**Consultation Response from KC,
Trees**

2025/90611 2, Kaffir Road, Edgerton, Huddersfield, HD2 2AN

Erection of extensions and alterations (within a Conservation Area)

Responding Ref: HU1/71

Description
SITE PLAN AND 3D SITE PLAN AS PROPOSED

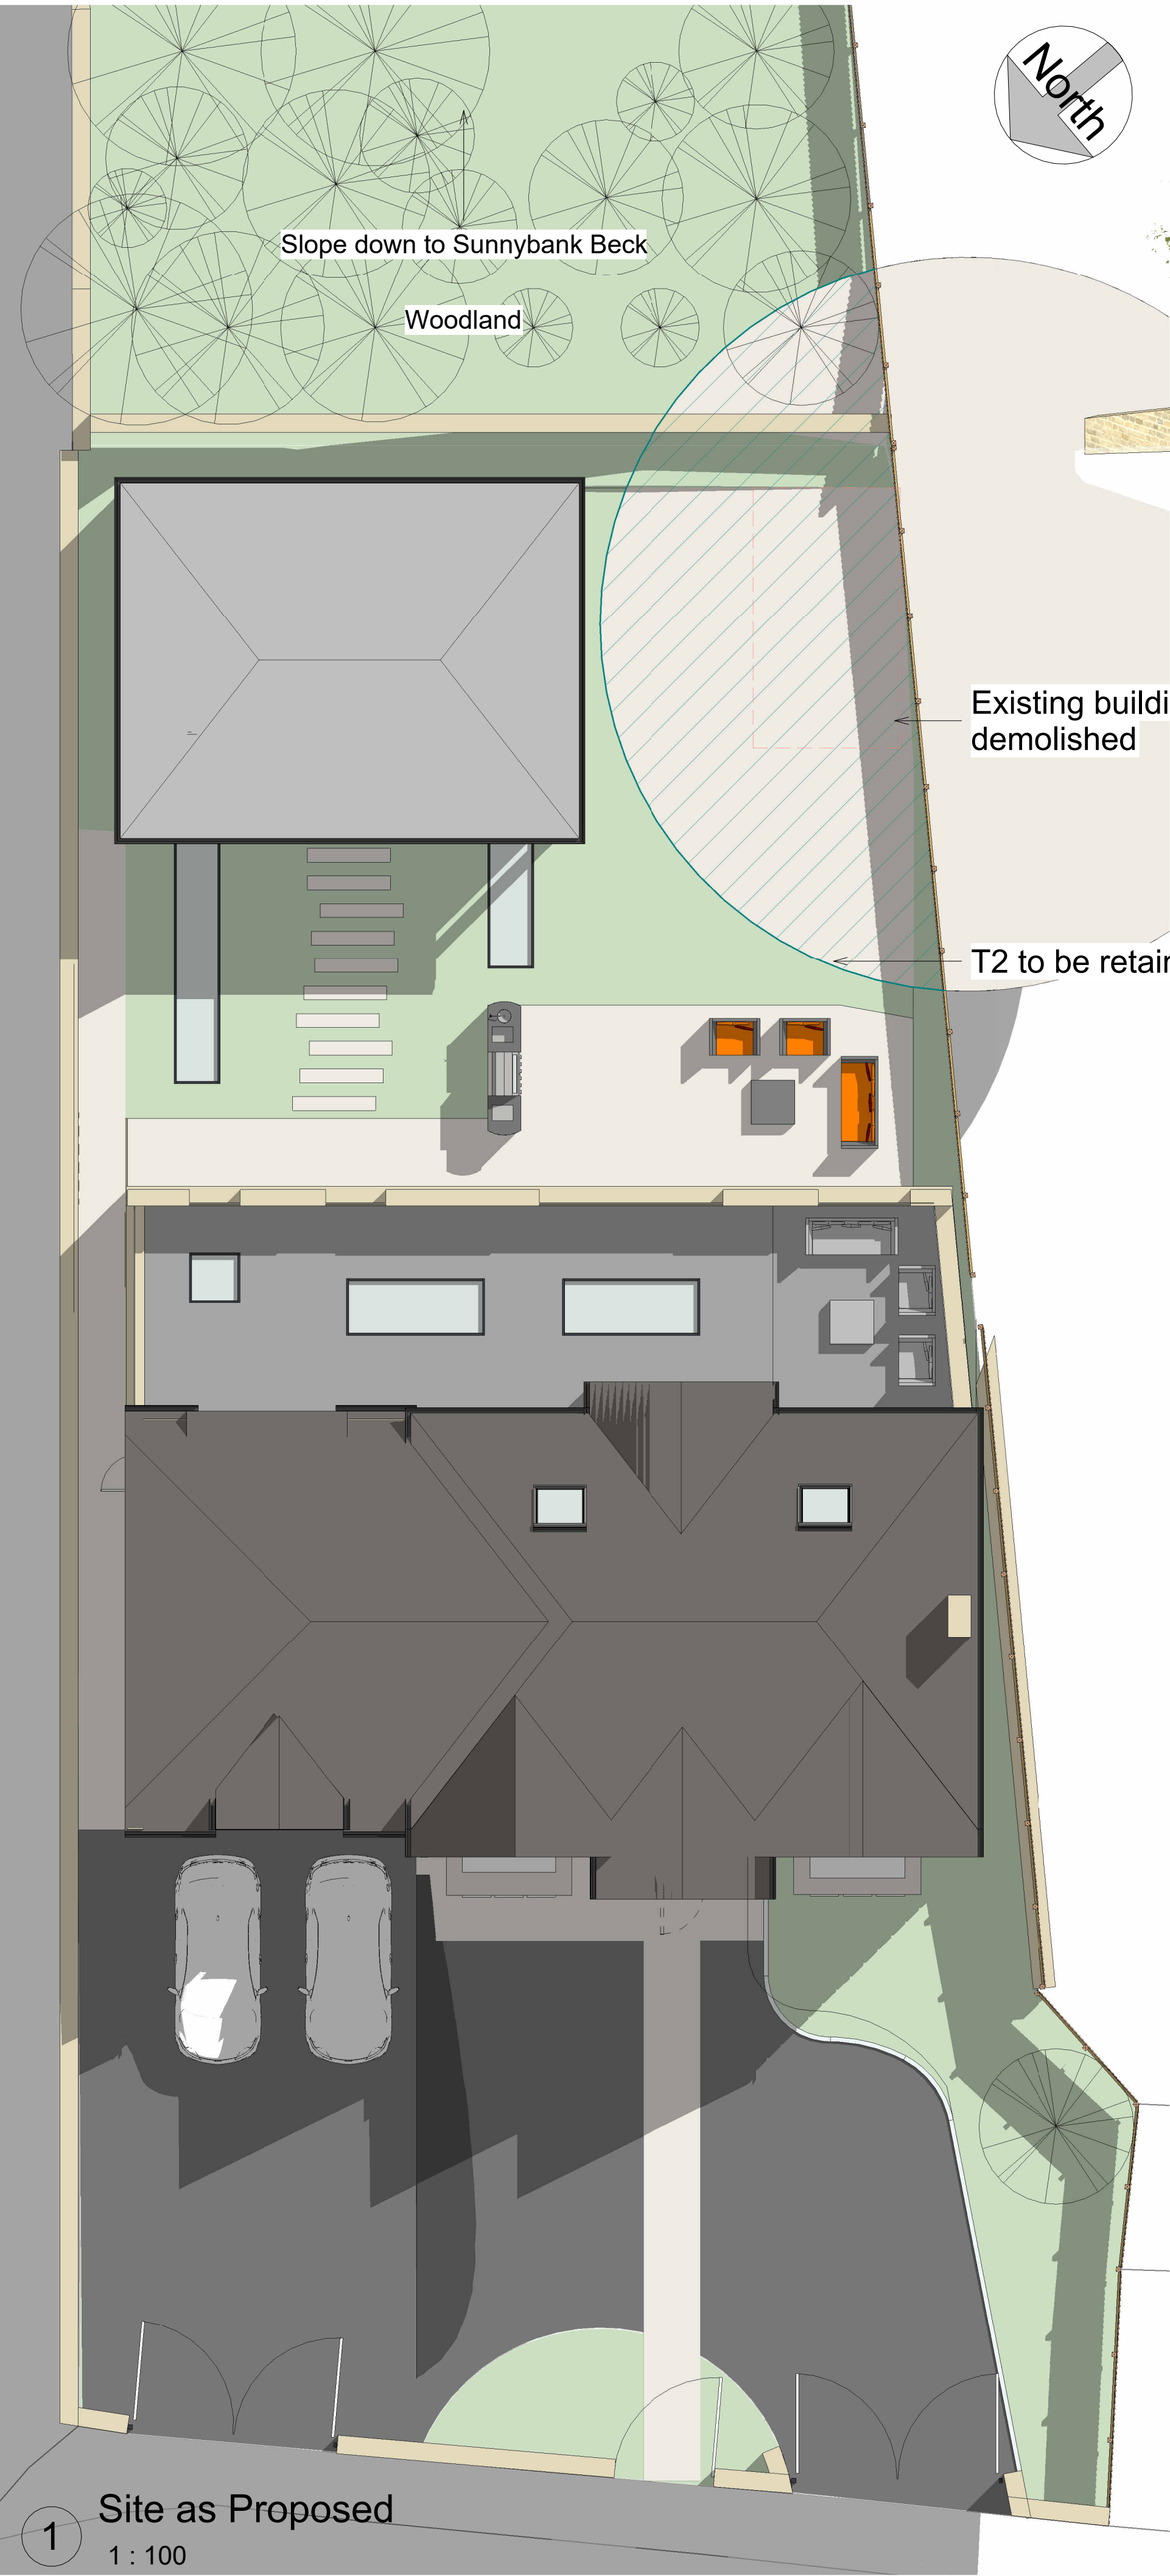
The submitted AIA shows that one tree T7 requires removal to facilitate the development. This tree is protected under the Edgerton Conservation area but the option of placing a TPO on this tree isn't viable due to its rarely viewed location, therefore, its removal is acceptable.

The rest of the development comes extremely close to the root protection areas of multiple trees, however it is believed to be achievable with great care being taken.

The Preliminary Tree Protection Plan looks adequate to protect the surrounding trees and this should be produced as part of an AMS.

There is no objection providing an Arboricultural Method Statement is submitted for review prior to construction starting.

Notwithstanding the submitted plans and information, an Arboricultural Method Statement, in accordance with British BS 5837, shall be submitted and approved in writing by the Local Planning Authority before construction commences. The method statement shall include details on how the construction work will be undertaken to minimise damage to the retained trees. Thereafter, the development shall be carried out in complete accordance with the Arboricultural Method Statement.
